**Subject:** 21/00517/F Wroxton MX track

I have looked at the ecological enhancement measures proposals, updated GCN survey and additional information sent to me and will therefore comment further.

#### **The Ecological enhancement scheme June 2021:**

### **Great Crested Newt Mitigation Scheme**

Figure 6 Landscaping plan, existing and proposed features

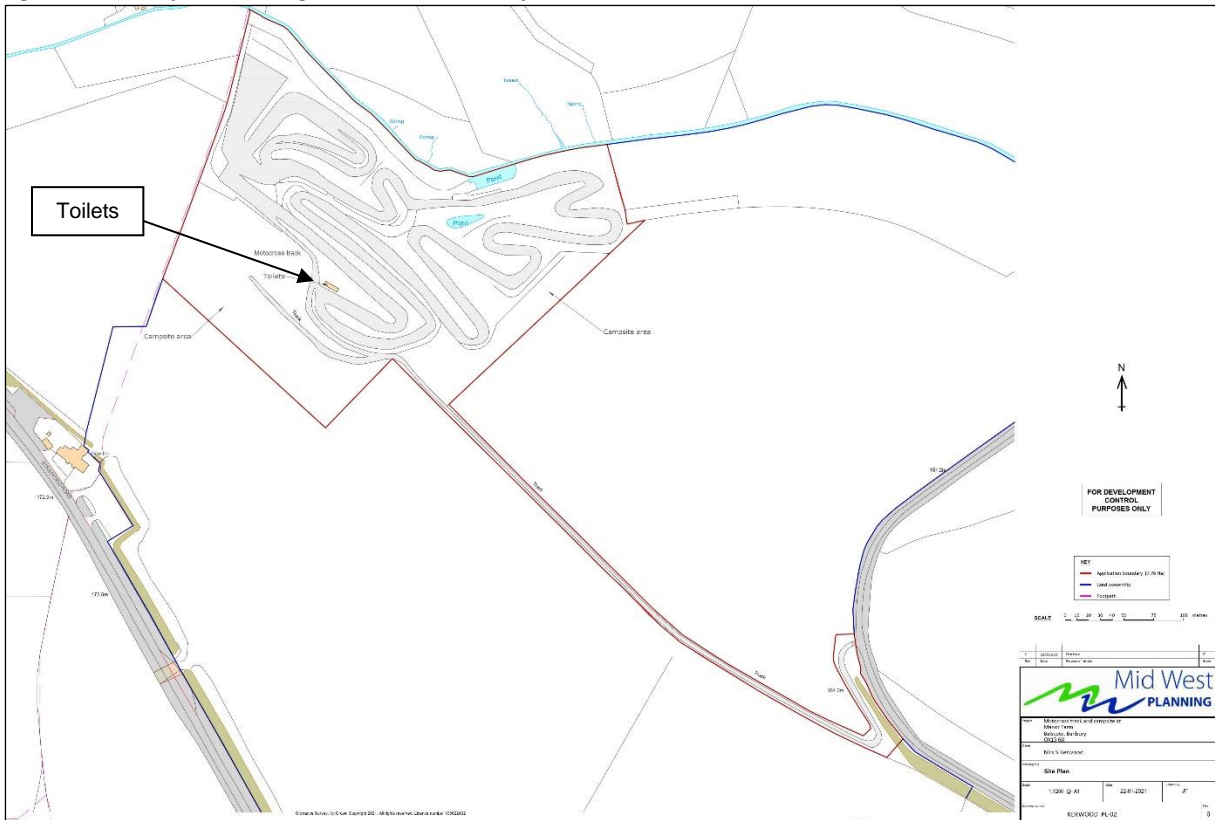
Is the new enhancement scheme to replace the Landscaping scheme of Jan 2021? It does not specify.. If these are to be looked at in tandem then I would have the following comments on the **landscaping scheme:**

The original landscaping plan is confused and not really coherent and if it is not fully replaced by a further document it would be very difficult to work to. It needs to be rewritten so it is clear and fits in with the Ecological enhancement plan now produced.

The landscape scheme mentions light grazing by sheep will occur. Is this also in the margins? How does this fit in with their management? Or will these be fenced off?

At least one of the areas proposed for small scale woodland creation appears to be on a very steep slope surrounded by track and skid marks. I am not convinced that this would be very successful for trees to survive or reach their natural size in terms of root protection zones? Again I would advise checking with the tree officer or landscape officer as to the likely success of this choice of site but I doubt anything beyond poor condition could be achieved.
